TRADITIONAL ARCHITECTURE GROUP

TAG PEER REVIEW- WOODFOLD VILLA, SHORROCK GREEN, MELLOR, 19 May 2022

The TAG Peer Review Group was invited by Francis Shaw of Shaw Jagger, the applicant's agent, to review the developing scheme subsequent to a pre-application submission with the local authority.

The application is to be made as an NPPF clause 80e application.

First Floor.
WOODFOLD VILLA

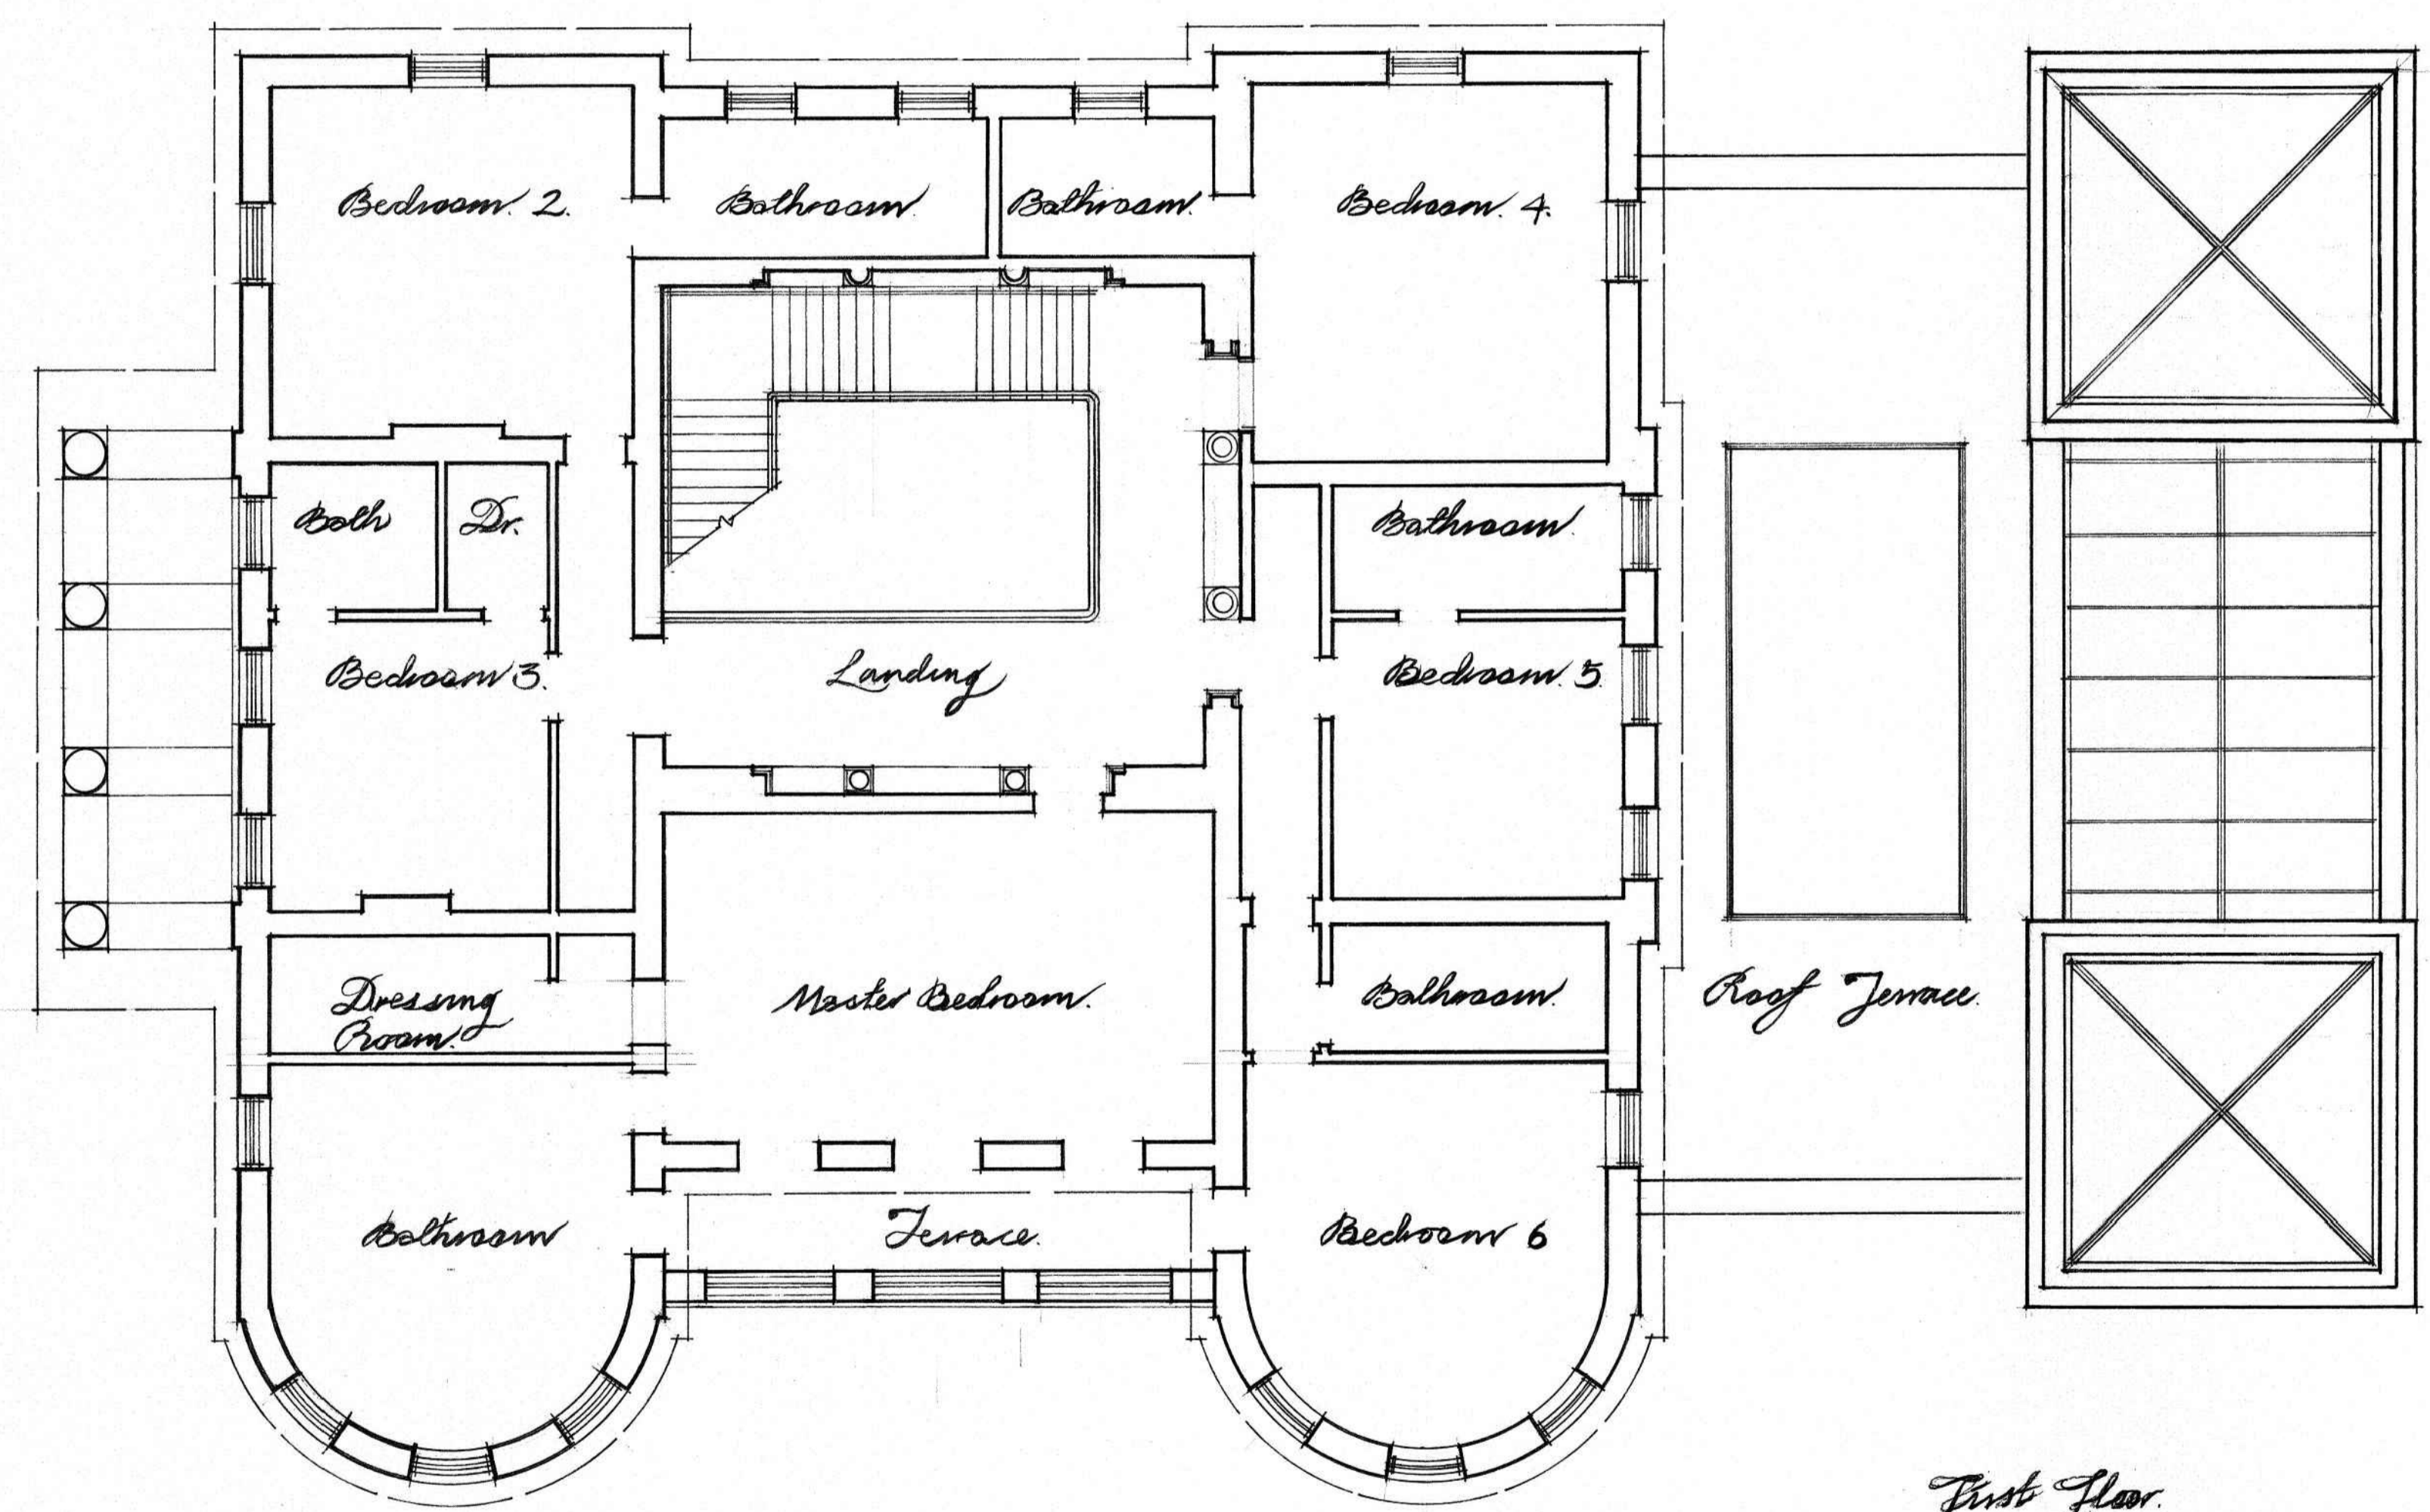
The subdivision of the dressing room and bathroom in the master bedroom (Bedroom 6) is a 'more' successful subdivision of the bay than its sibling bay at the other side of the house.

Job No	DWG No	Rev
383/01	(02)	003 #

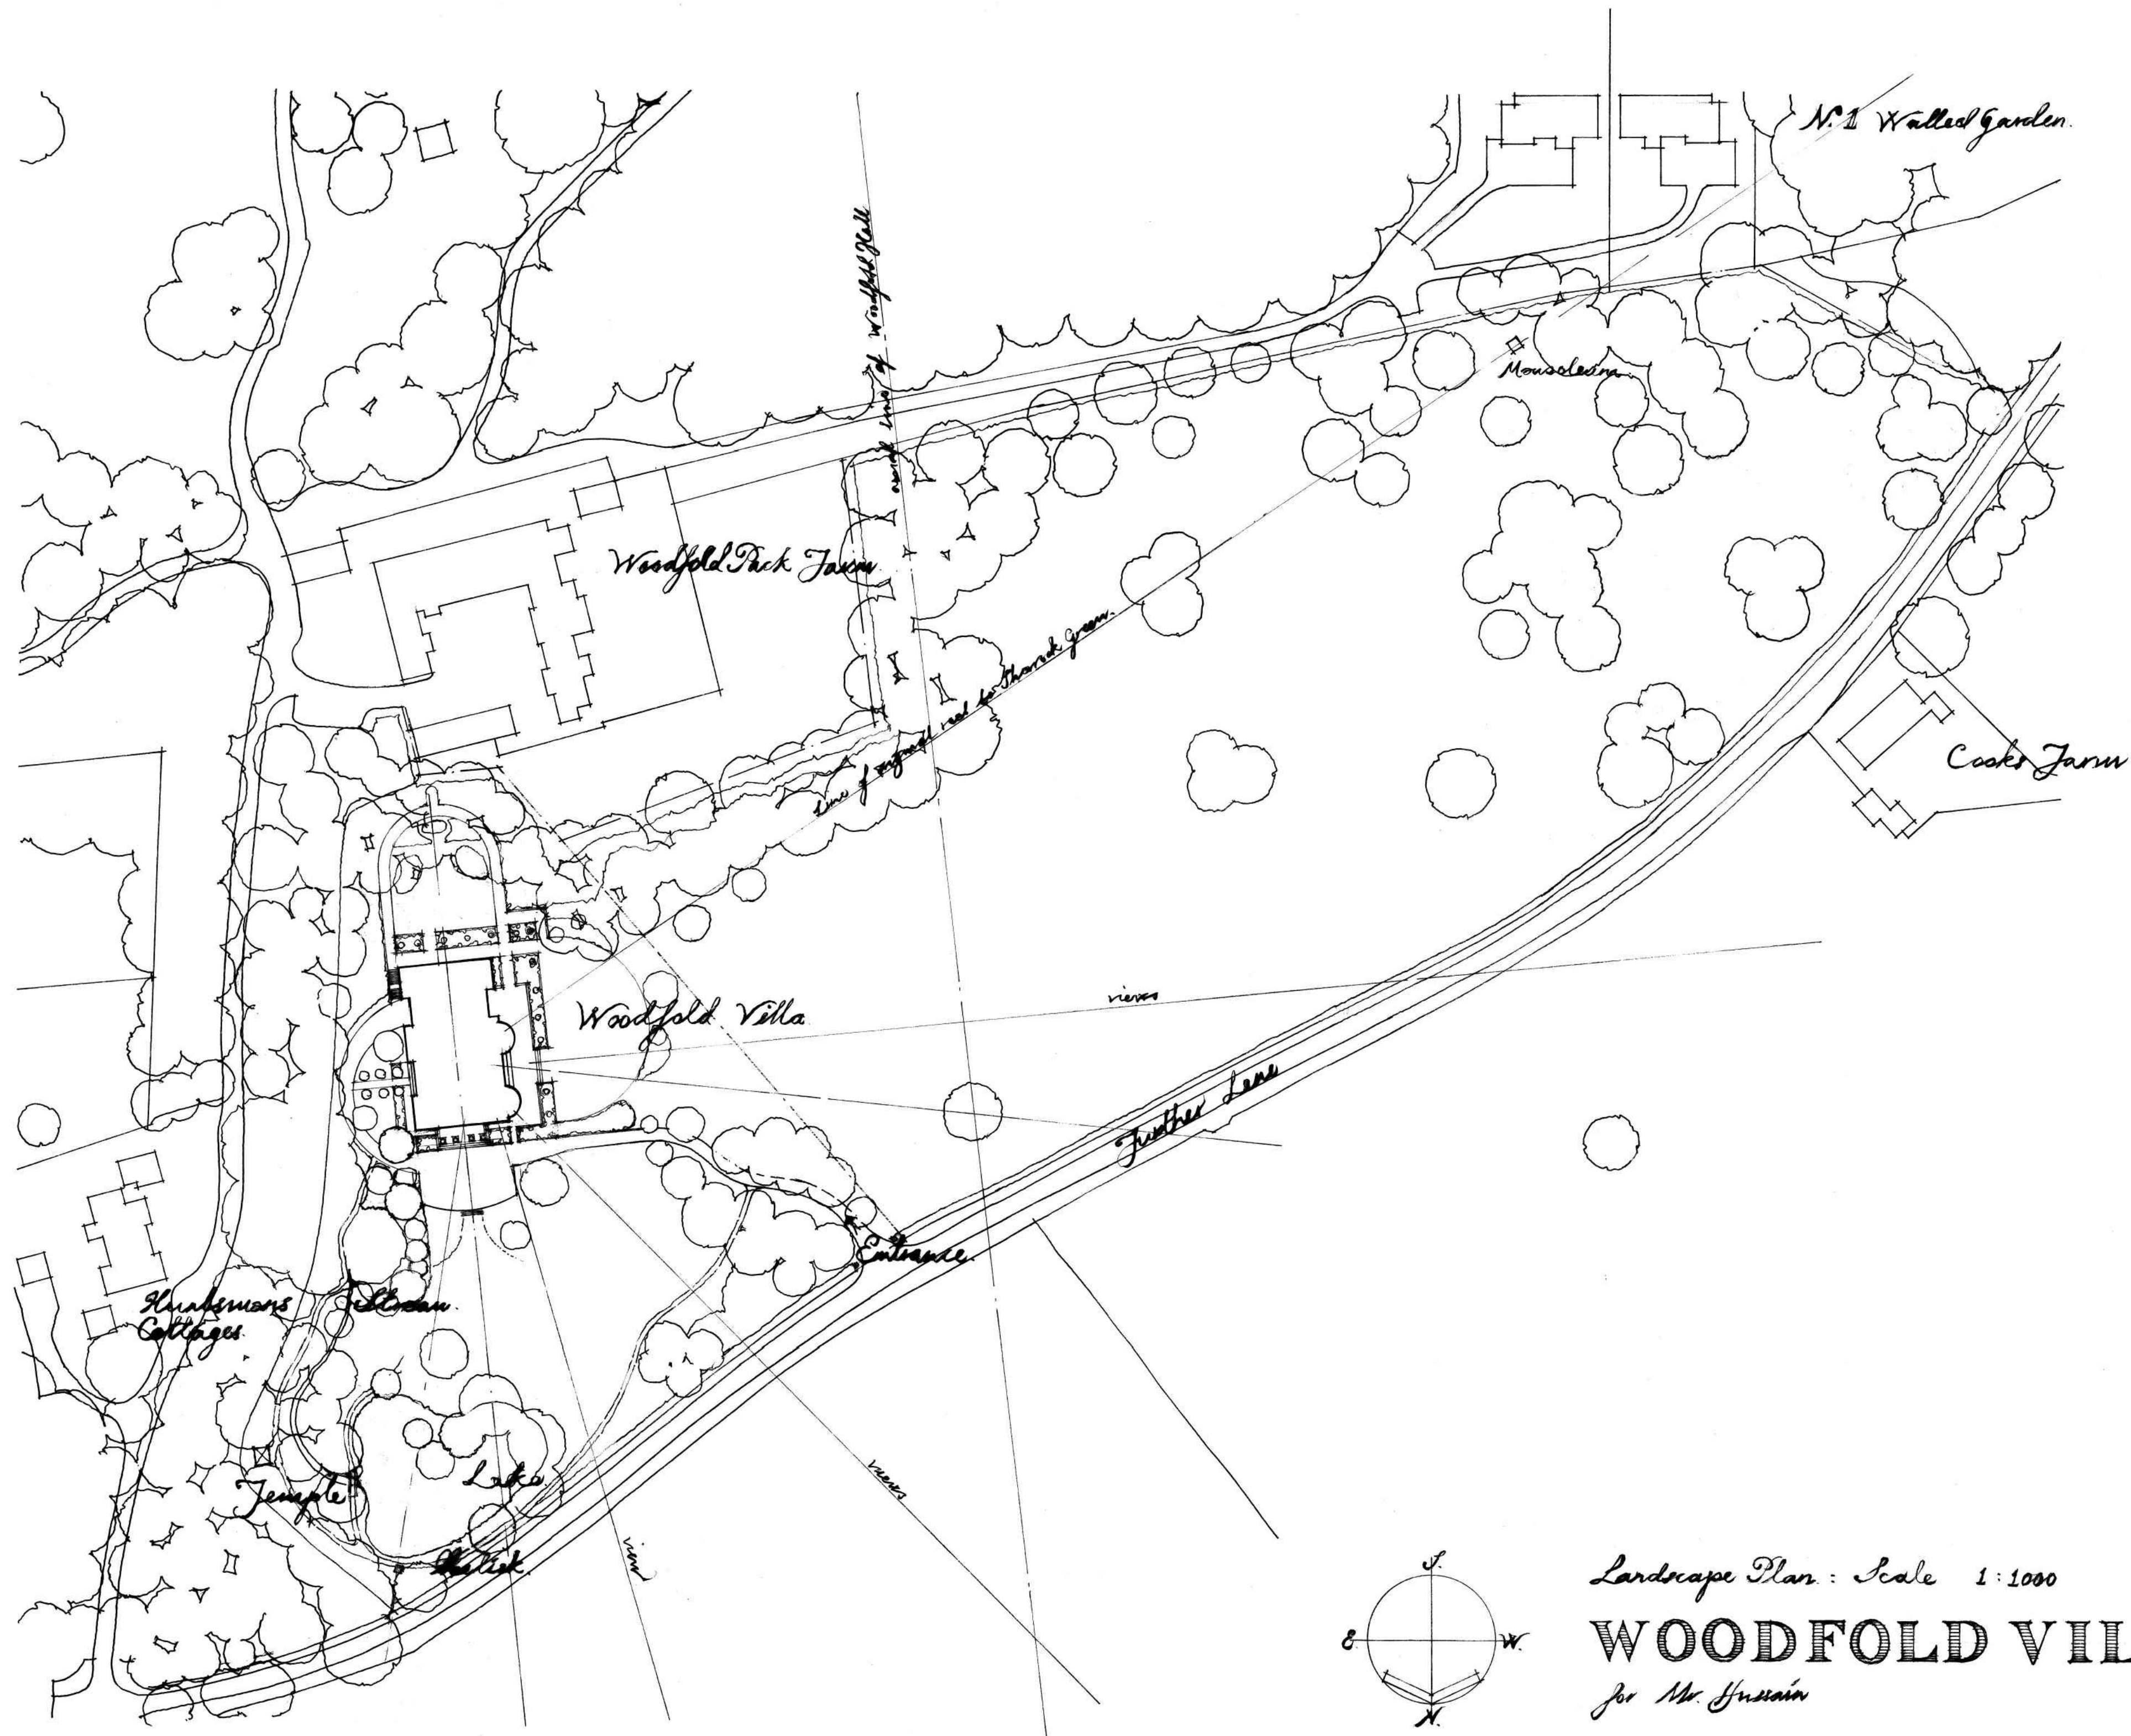
It was a concern of the design review team that the proposed new house should have a garden setting of a size to match its quality.

In its original form and conception the proposed new house was restricted to a limited site. However, the Panel understood that there is more land available to the applicant towards the west and inclusion of this would make much better sense of the placement of the new dwelling. As a bonus, this will allow a suitable quantum of gain in terms of biodiversity and landscape improvement particularly along the site boundaries.

Furthermore, extending the site west to include Cook's Farm will enable the creation of a suitable sized landscape setting for the proposed house and allow a seamless flow between the surrounding context and the new house. Extending its terrain would also have the added effect of completing and securing the estate's historic northern edge onto Further Lane in an appropriate manner.

The Panel felt, therefore, that the acquisition of Cook's Farm is key to the success of the project. The access point to the site should also be relocated westwards on the assumption that Cook's Farm becomes part of the application site.

The enhancement of planting along the southern boundary of the site and west into Cook's Farm will improve the southern boundary and screen views to Woodfold Park Farm. The inclusion of clumps and individual trees will frame views to and from the house from Further Lane.

The lake is an attractive feature that would be improved by increasing its size.

Justification will be required for any removal of the boundary hedge from an ecological point of view. Care will need to be taken to ensure that there is an overall ecological benefit to the general replacement landscape along and within this boundary.

The proposals bring the estate to the boundary with Further Lane, and consequently into the public realm. This is a strong planning benefit because it will allow the public to appreciate the park; something that is currently not possible. Also, from a planning gain point of view, perhaps one (or maybe two) break out points could be created along the boundary located as far west as possible and as far away from the house as possible.

These could be very small indents into the site with composed long views towards the new house. The indents might include some very basic amenities such as benches, coordination with local footpaths, history boards etc.

WOODFOLD VILLA - EAST ELEVATION

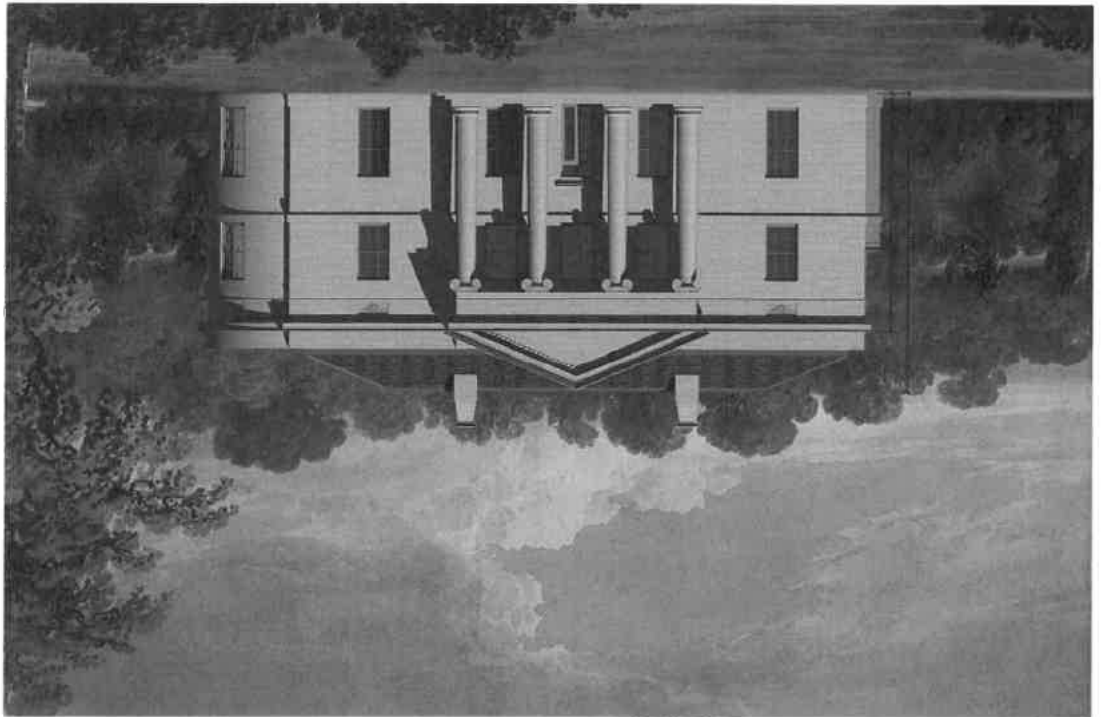
The separation of the pool from the main house (via the orangery) is arguably more successful on the east elevation than the west elevation. Might the detailing of the west elevation of the orangery be gently simplified to further emphasise the subservience of the single storey elements?

The roadside elevation should be extended to show new context, elements proposed in the grounds etc.
